STATE OF NORTH CAROLINA  
DEPARTMENT OF TRANSPORTATION

March 13, 2008

Subject: Request for Section 401 and Section 404 Individual Permit Modification and Permit Extension for Widening of US 15-501 from north of SR 2294 (Mt. Moriah Road) to south of SR 1116 (Garrett Road) in Durham County. Federal Project No. NHF-15 (8), State Project No. 8.1352301, Division 5, WBS Element No. 35012.1.1, TIP No. U-4012.

23-JAN-2008 13:23:39
F:\pols\J\15-501\edge

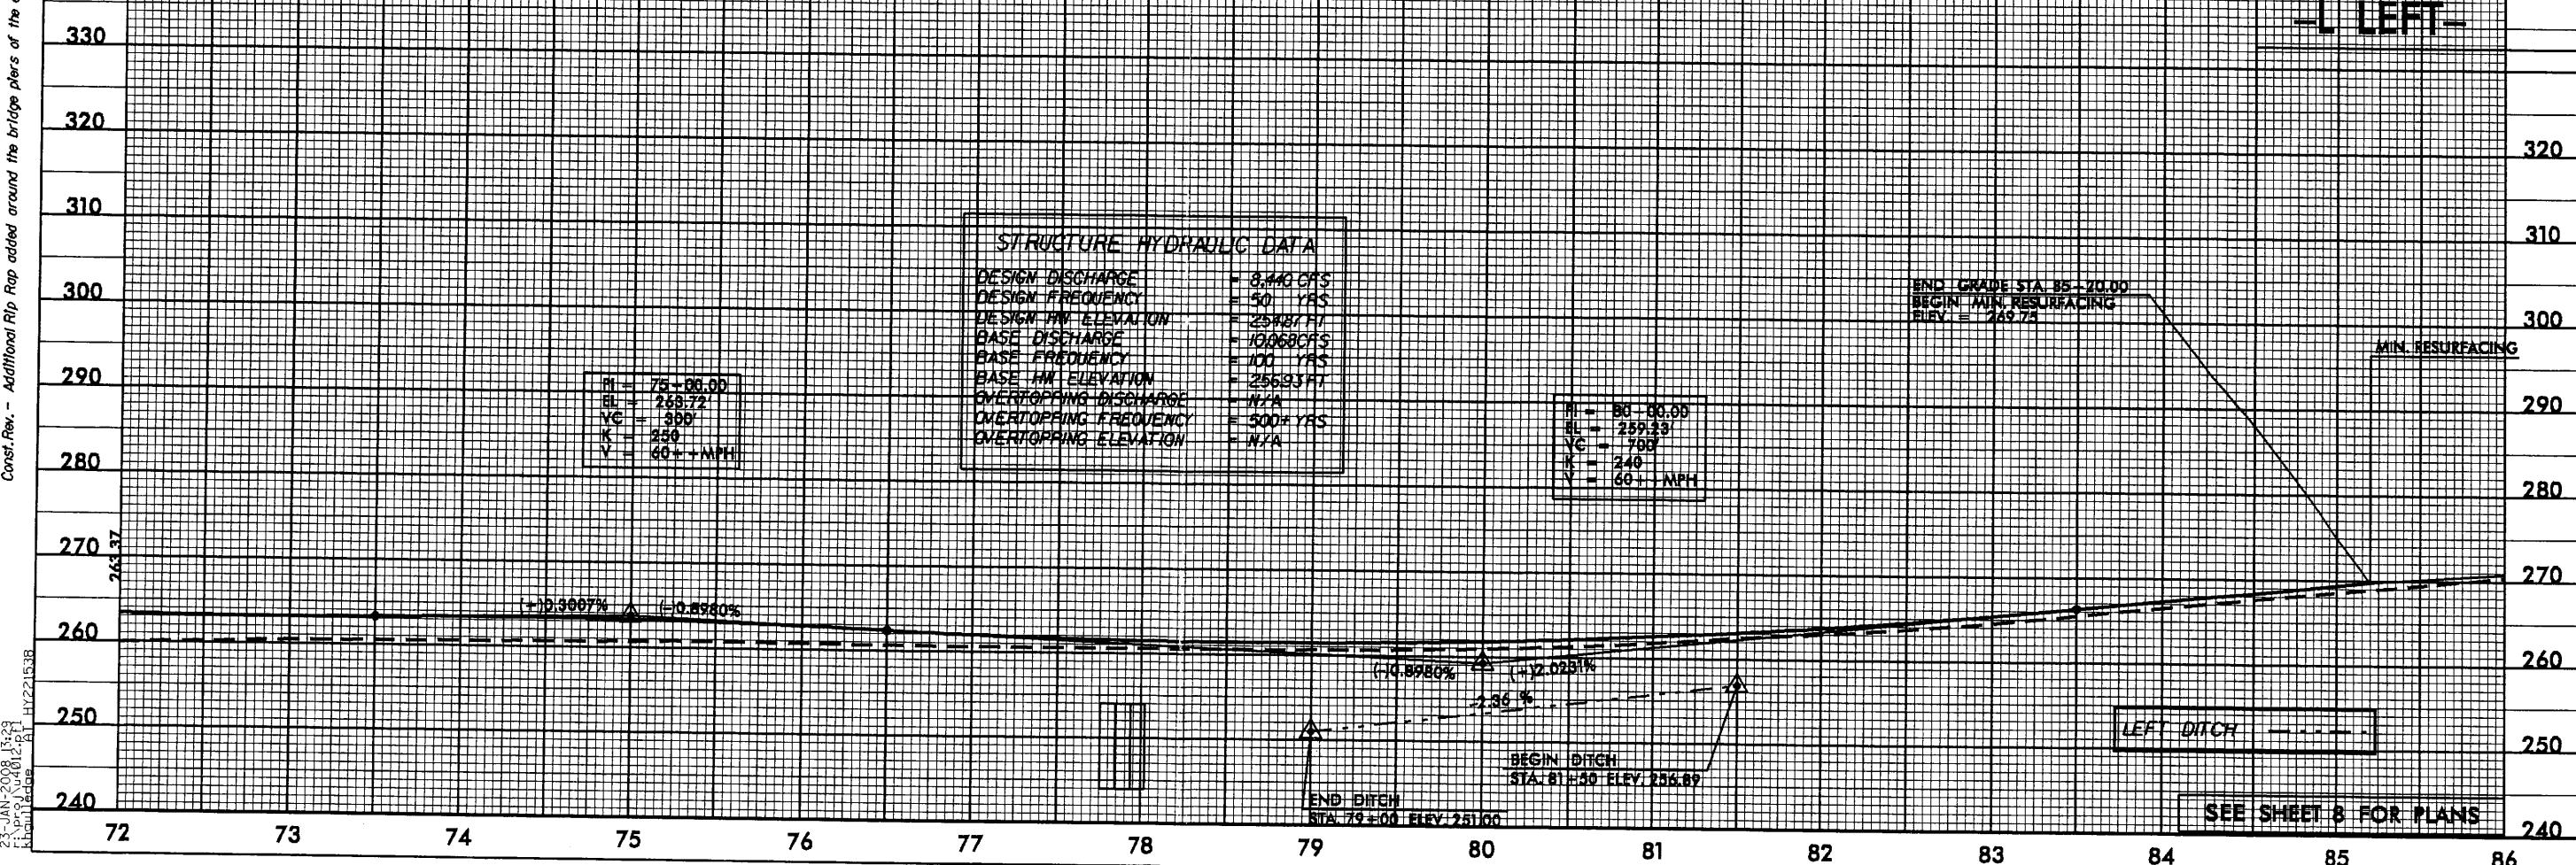
The described changes were to be depicted on the plan and profile views. This information is not depicted on any permit drawings submitted to the regulatory agencies as part of the permit application dated December 13, 2004. The attached revised permit drawings 3, 7, 11 and 14 of 15 indicate the permanent installation of Class II rip rap below normal water surface on New Hope Creek at 70+35 and 70+75 -L- to stabilize the stream banks after removal of existing piers.

Jurisdictional Changes: The installation of Class II rip rap below normal water surface on New Hope Creek at 70+35 and 70+75 -L- will result in an additional 72 linear feet of permanent stream impact due to bank stabilization. The revised plan sheet 7 is also included.
